Subject: 2020/90441 - Pennine Service Station, Bradley Road, Bradley, Huddersfield HD2 1QD

Further to the comments on the lighting design proposals for the above we have been in consultation with the lighting manufacturers and confirm the following in respect of the outstanding concerns:-

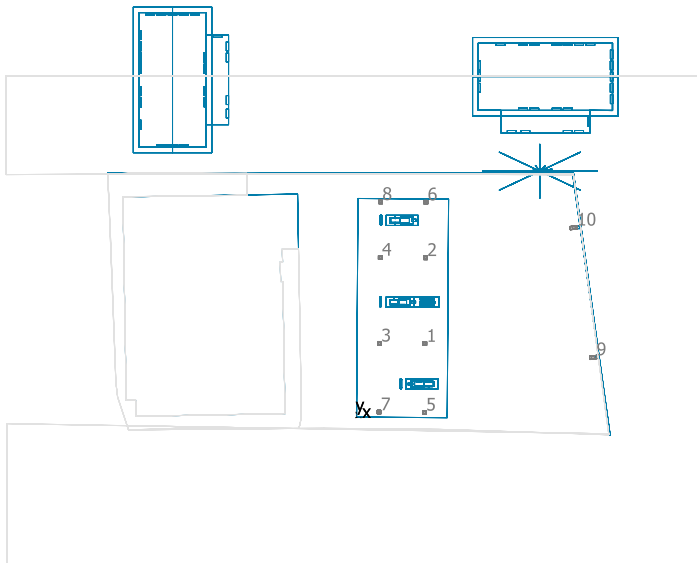
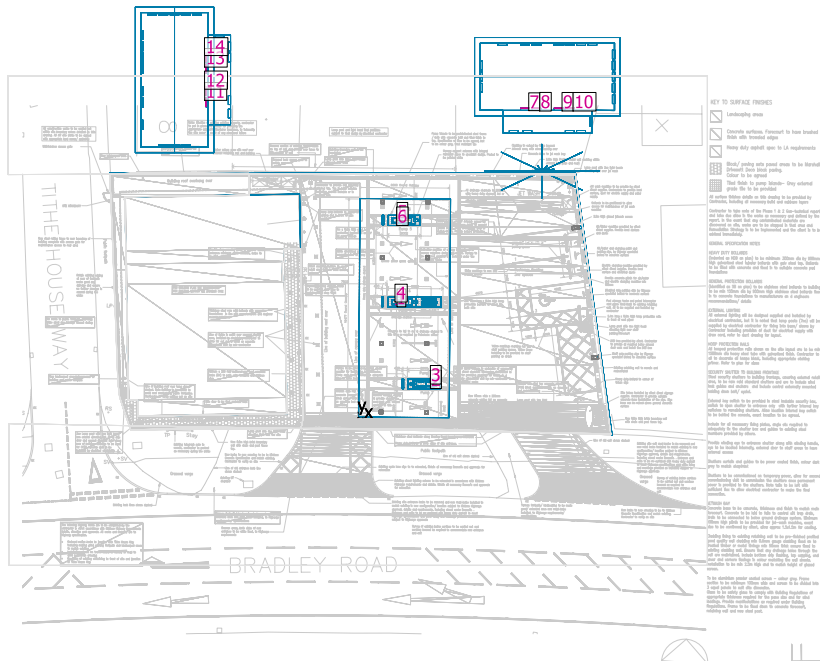
4. The plan on page 5 of the report indicates nearby residential properties but way that they are shown on the plan does not accurately represent the real situation.

Vertical (perpendicular) values are quoted at the numbered positions on the plan at the top of the page.

For the pump nozzles the values would need to be at least 150lux to satisfy BP for example (greater than 100 for the whole of the pump face for APEA IP COP). Some are significantly higher but this is only because the adjacent lights are not possible to get further away because the canopy is relatively small. It is not really possible to turn them down more as there is a requirement to maintain enough light as you get away from the pumps to cover the pedestrian hazard.

The plan included in the reports is not to scale and indicative of the arrangement in reality. Given that we have not carried out a full topographical survey of the whole neighbourhood, distances to the adjacent properties have been extracted from Google maps. The report provides the predicted light that will fall on the vertical surfaces of the adjacent properties at the relevant points. The levels at the adjacent properties are at or below 1 lux, which is normally considered moonlight.

Workplane (Canopy) / Perpendicular illuminance (adaptive)**Workplane (Canopy): Perpendicular illuminance (adaptive) (Surface)****Light scene: Light scene 1**

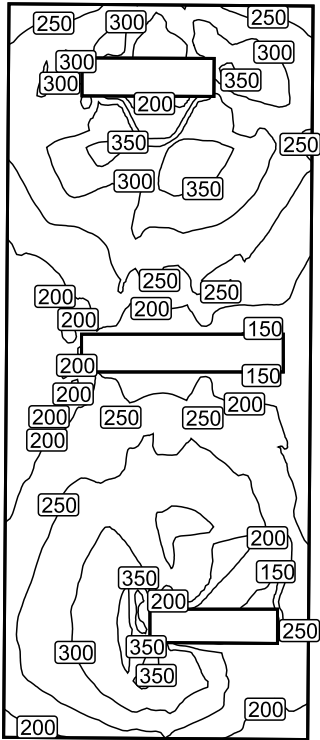
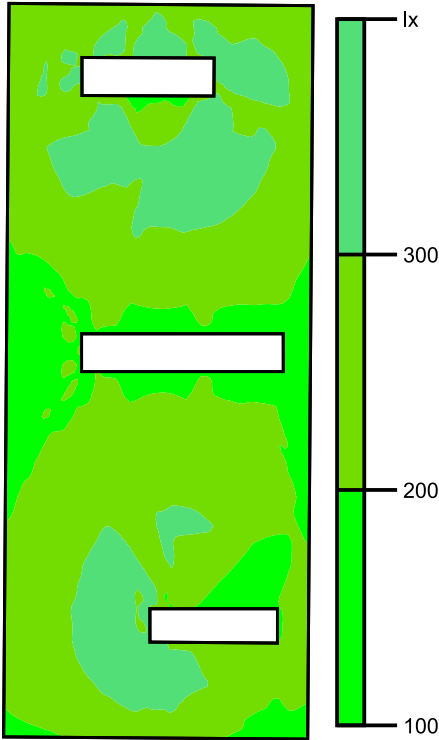
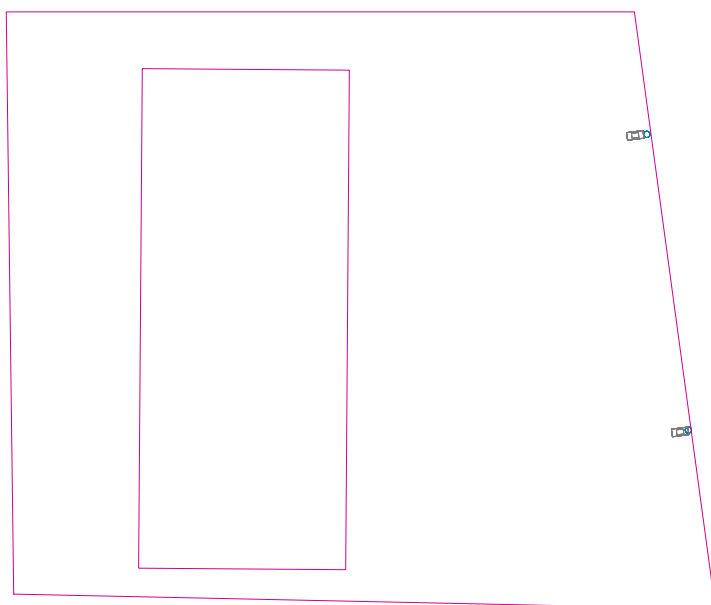
1. The scheme again uses unacceptable ambiguous references to "perpendicular" Illuminance instead of horizontal and vertical illuminance as required by the condition.

Horizontal illuminance average at ground level is 254 lux under the canopy (min required for BP is 250 and for Shell is 300 as a guide). These levels are an average but there is a requirement in BS EN 12464-2 table 5.6 for fuel filling stations that the ***maintained*** level of illumination is 150 lux so this is borderline at the bottom of this with a minimum of 133 lux in one spot.

Horizontal light plot under the canopy at ground level using isolines for more detail is shown on page 7.

Workplane (Site) / Perpendicular illuminance (adaptive)**Workplane (Site): Perpendicular illuminance (adaptive) (Surface)****Light scene: Light scene 1**

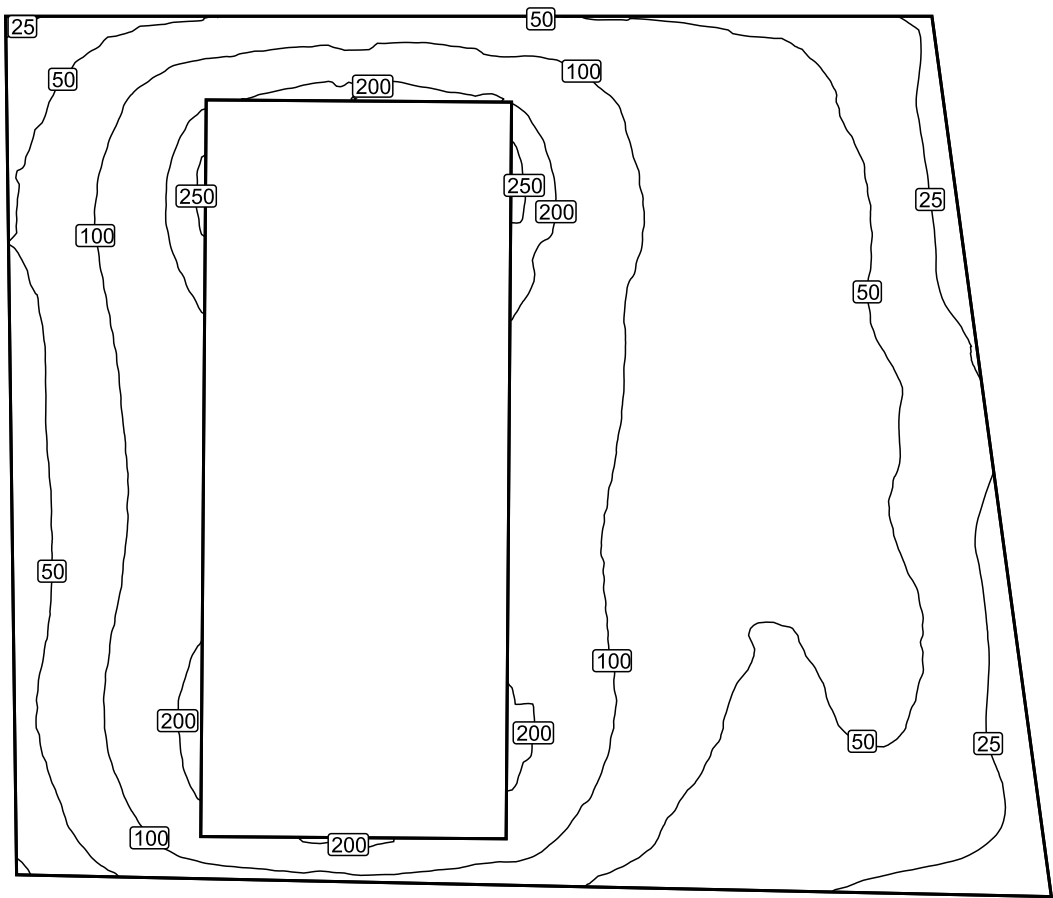
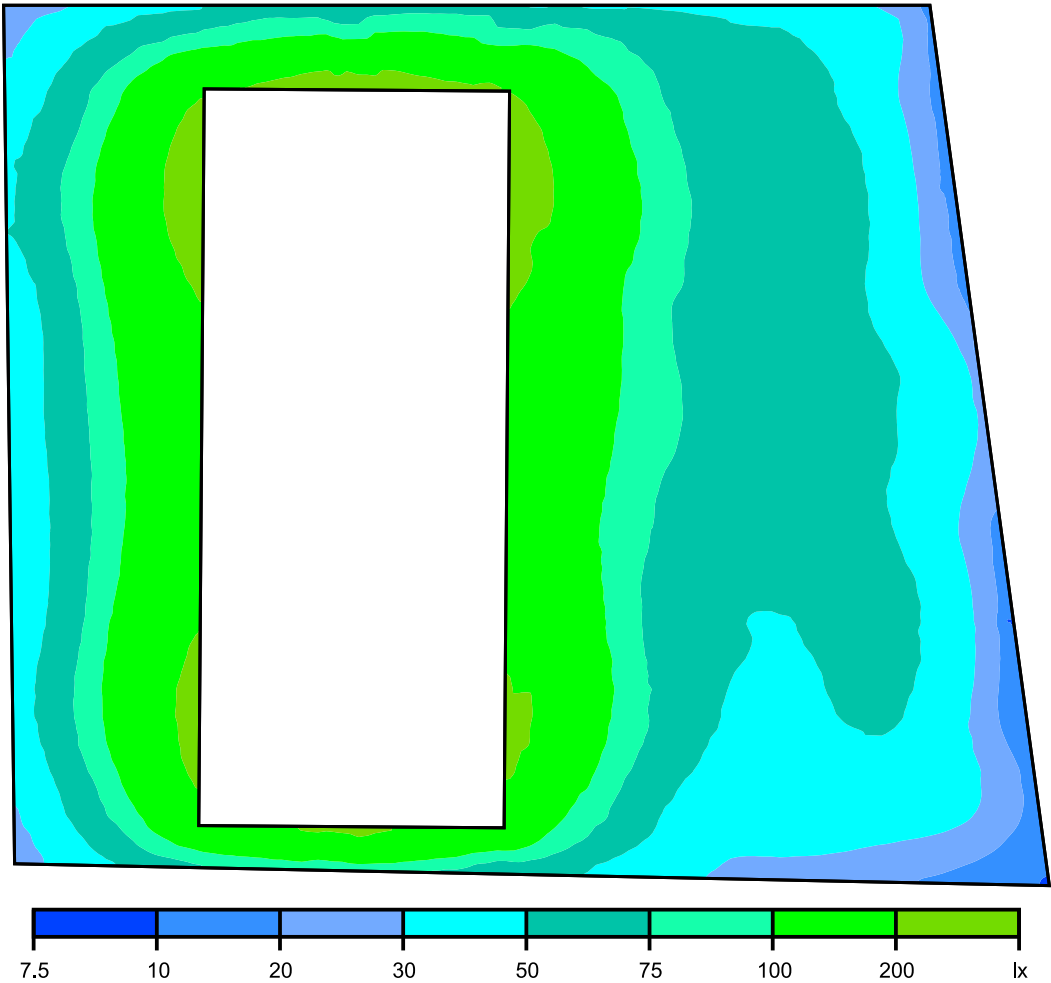
2. It provided no reference to any recognised UK guidance to demonstrate that the proposed levels of illuminance are appropriate and not excessive.

Horizontal plot of the forecourt area outside the canopy again using isolines which shows that the majority of the forecourt area meets BS EN 12464-2 table 5.6 where vehicles are expected to drive as well as for mixed pedestrian/vehicle areas as table 5.1. Again the proposed lighting levels are sufficiently low that there is only borderline compliance with the standard at the edges of the site and there may well be a need for any small service point machines to have integral illumination to meet their respective specs.
